CITY OF ALBUQUERQUE

**RE: MDS - Montage Subdivision Unit 7 on Bobby Foster
Grading and Drainage Submittal for Preliminary Plat and Grading Permit
Engineer's Stamp Date: 6/30/22
Hydrology File: R16D100A**

TITLE: HYDRAULIC ANALYSIS MONTAGE 7 - MESA DEL SOL			
Design Review Committee	City Engineer	Mo./Day/Yr.	Mo./Day/Yr.
Last Update			
City Project No.	Zone Map No.	Sheet	OF EXHIBIT 2

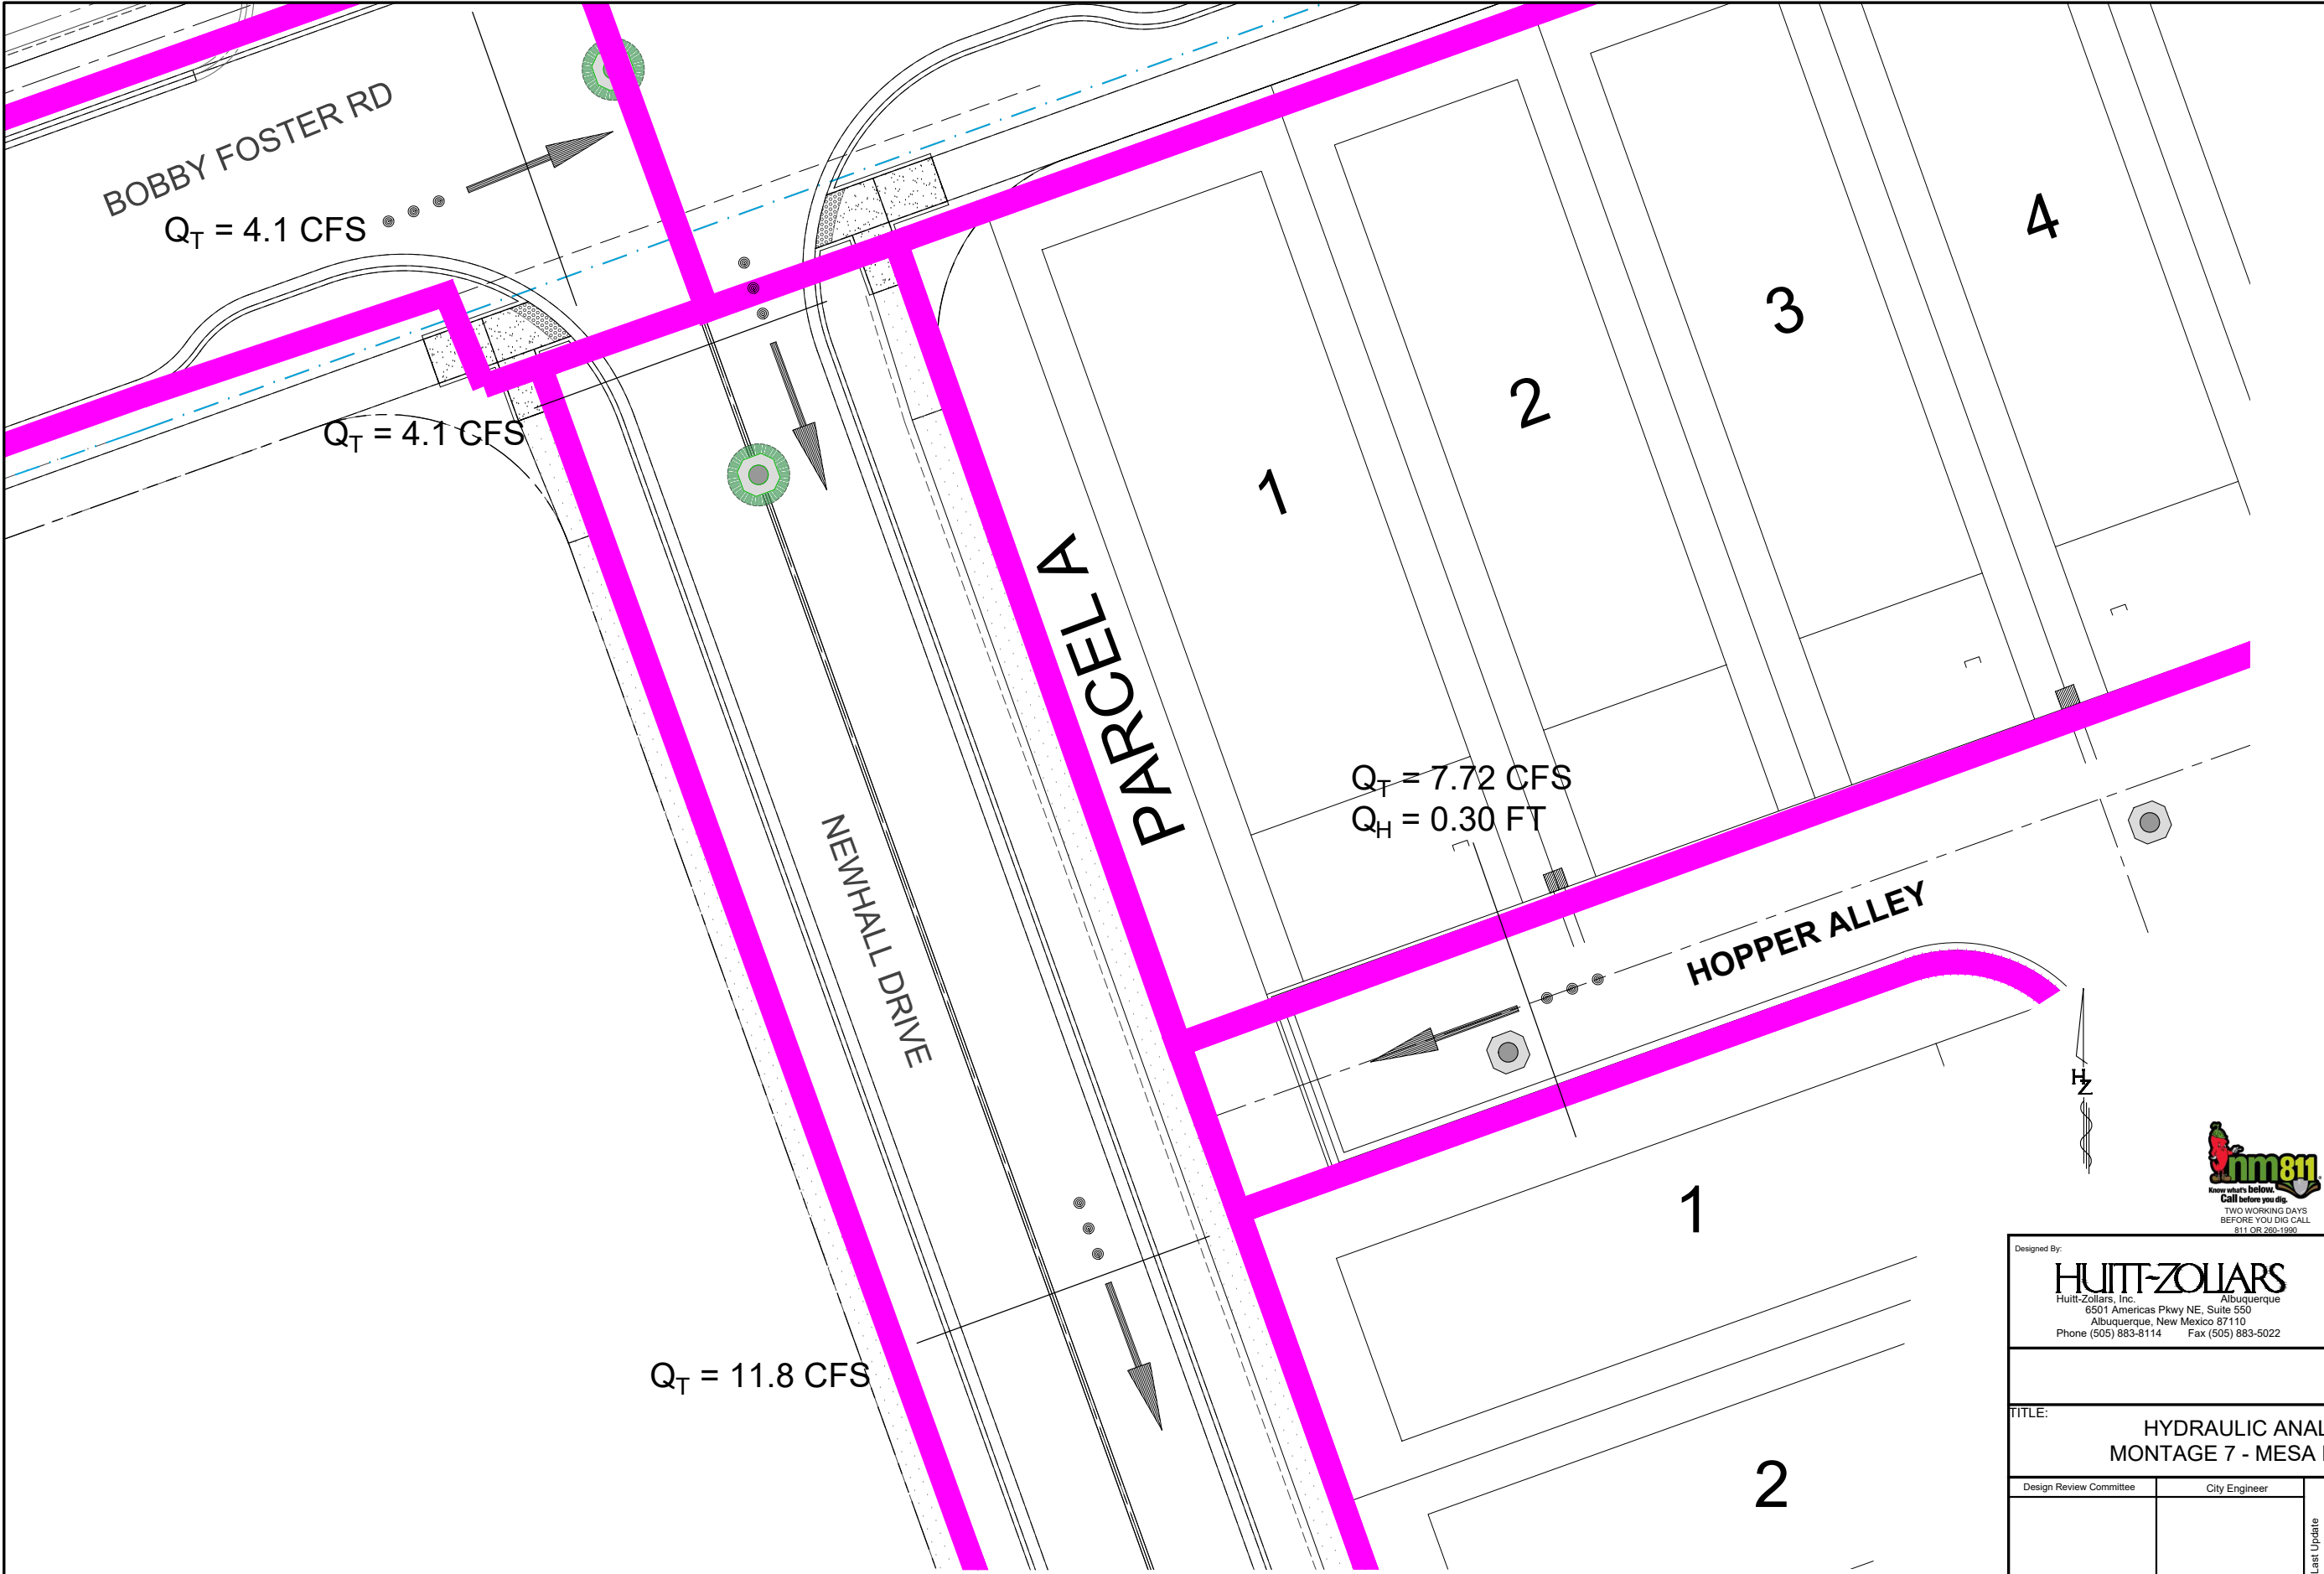
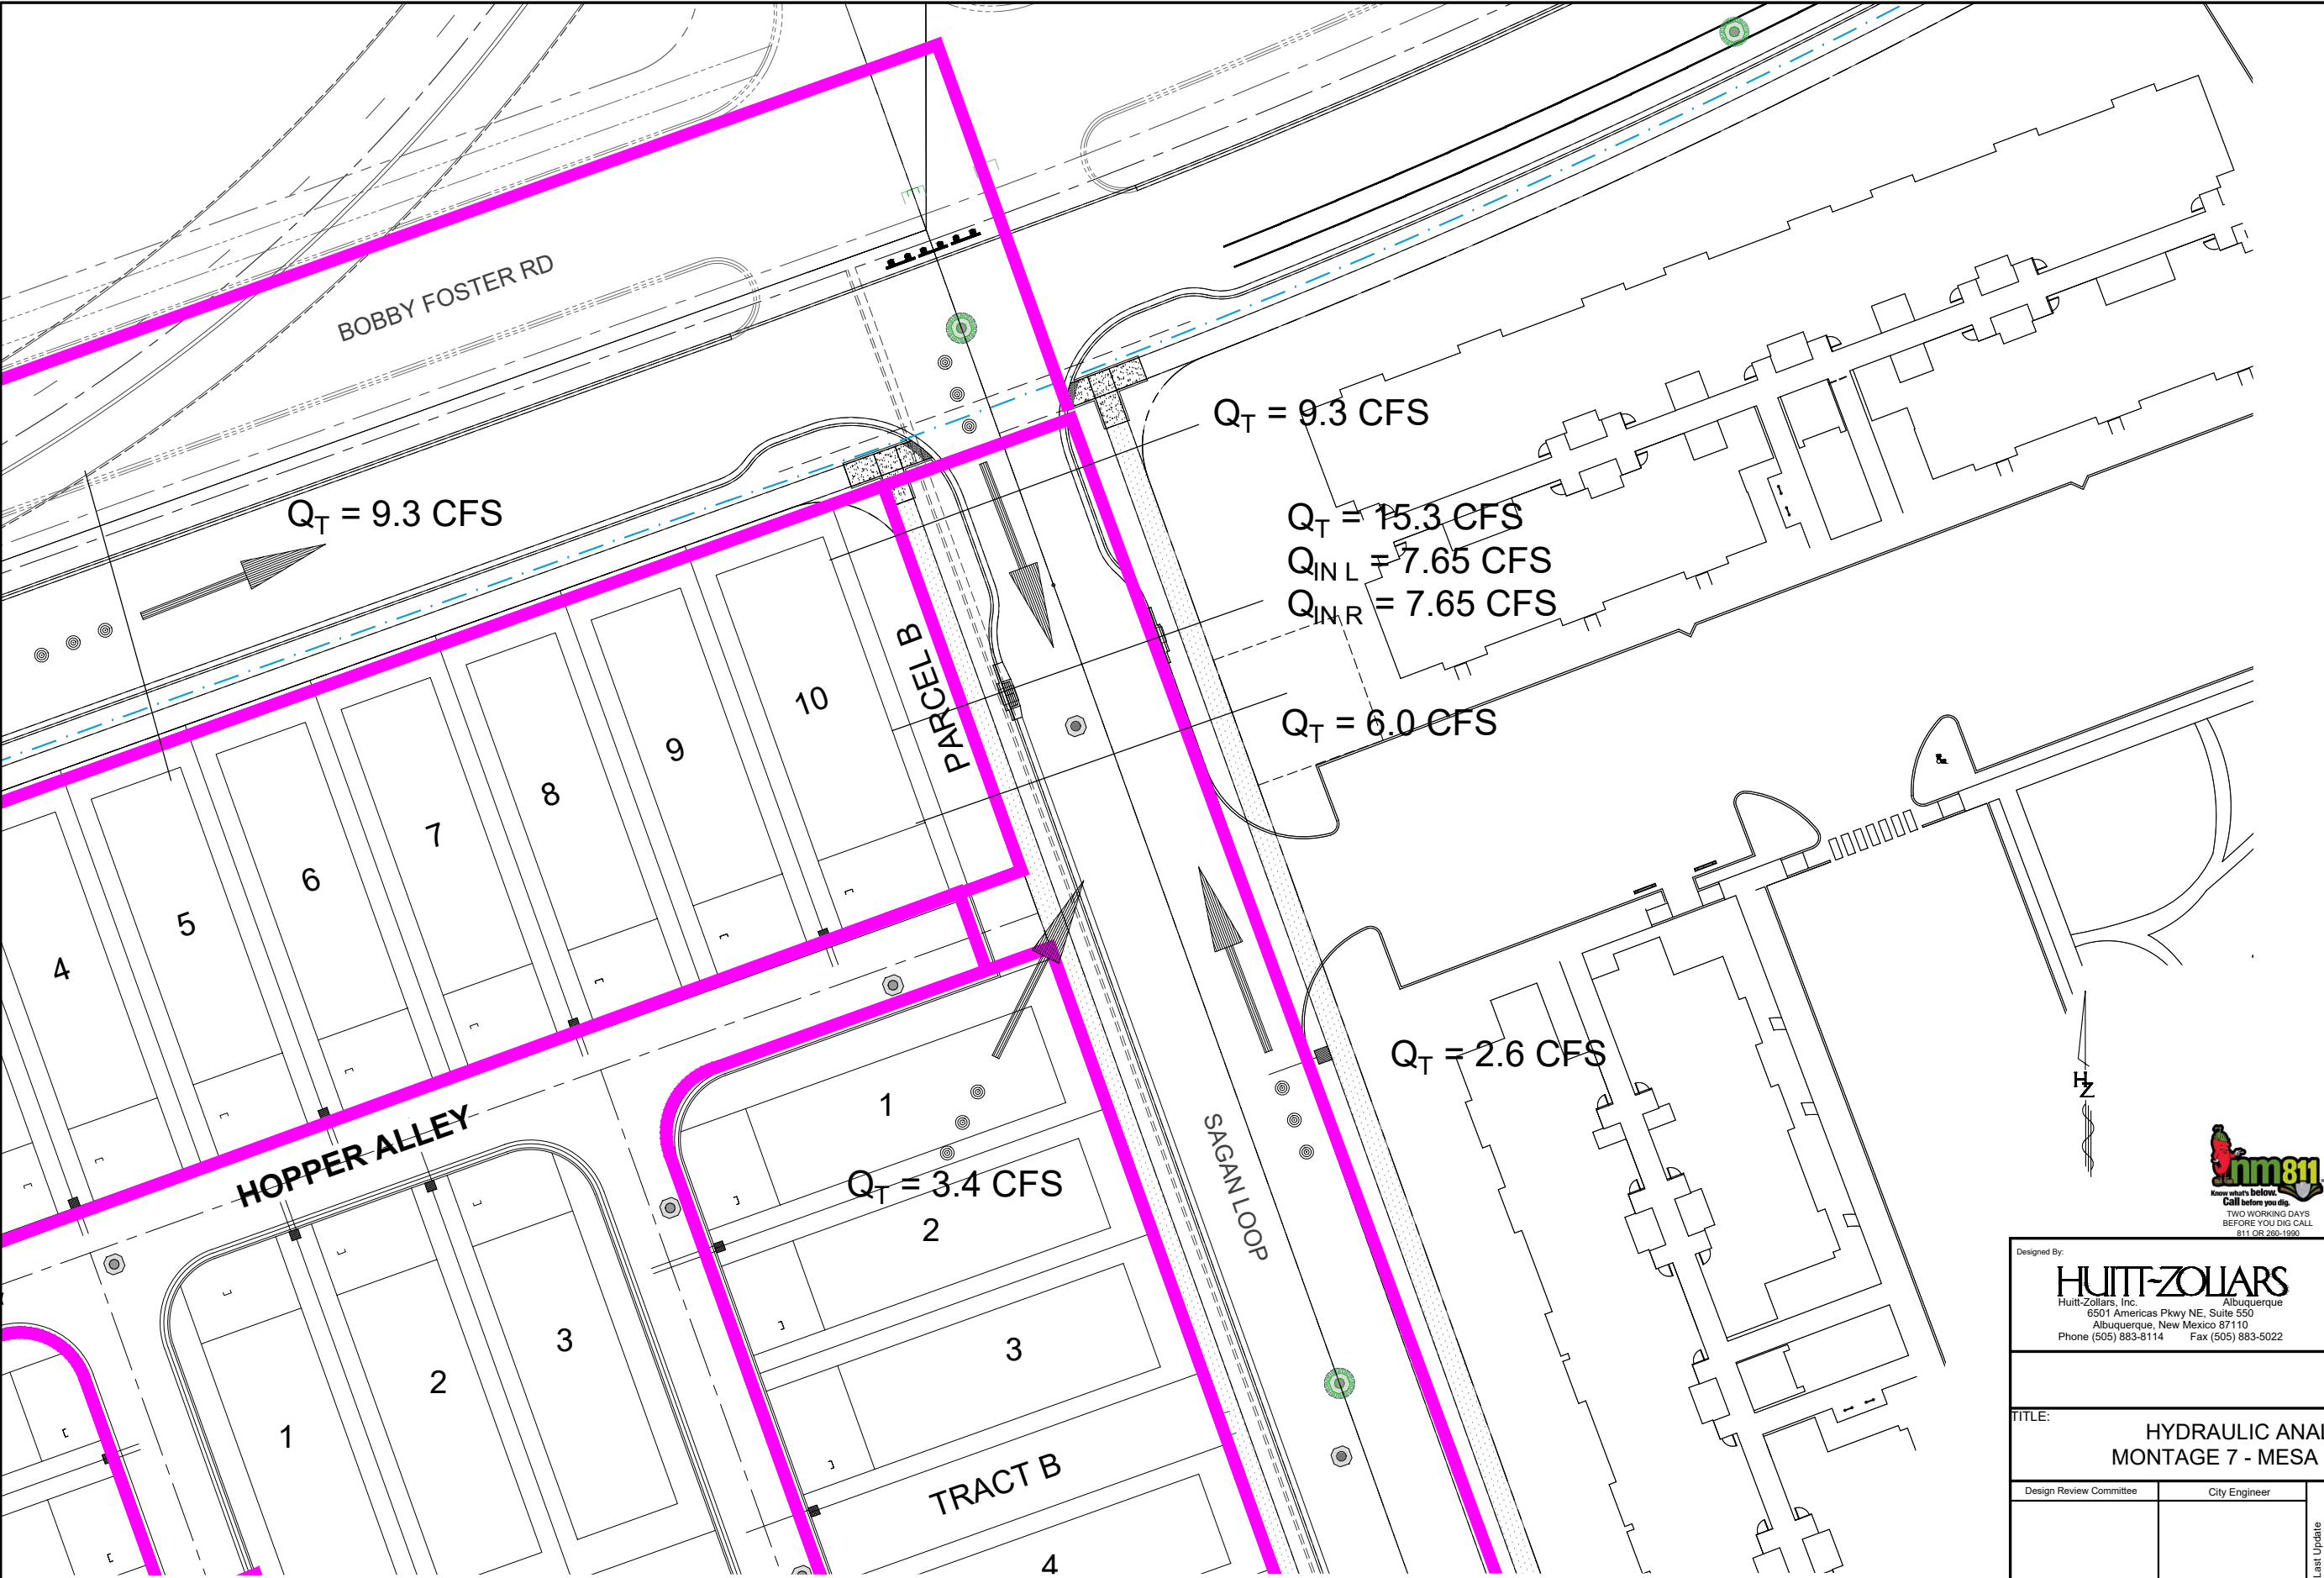
3. As proposed, this entire site will drain to Newhall Drive. The site must demonstrate adequate downstream capacity per § 14-5-2-12(G) of the Albuquerque Code of Ordinances. Detailed hydraulic analysis of surface and subsurface conveyance systems of the existing downstream street is required prior to approval for PP.

6. Hydraulic grade line calculations and pipe profiles will be required prior to drainage report approval for (WO).
7. Provide surface drainage analysis demonstrating that the 100-year HGL remains at/below top of curb, and the 100-year EGL remains within the ROW for the onsite streets and alleys and the adjacent streets that receive drainage from this site. The report has only one surface analysis (for a 32' street at 0.5% slope with 6" curbs, gutter depression is missing and location is missing). Identify the location of each analysis point and account for the effects of local gutter depression.
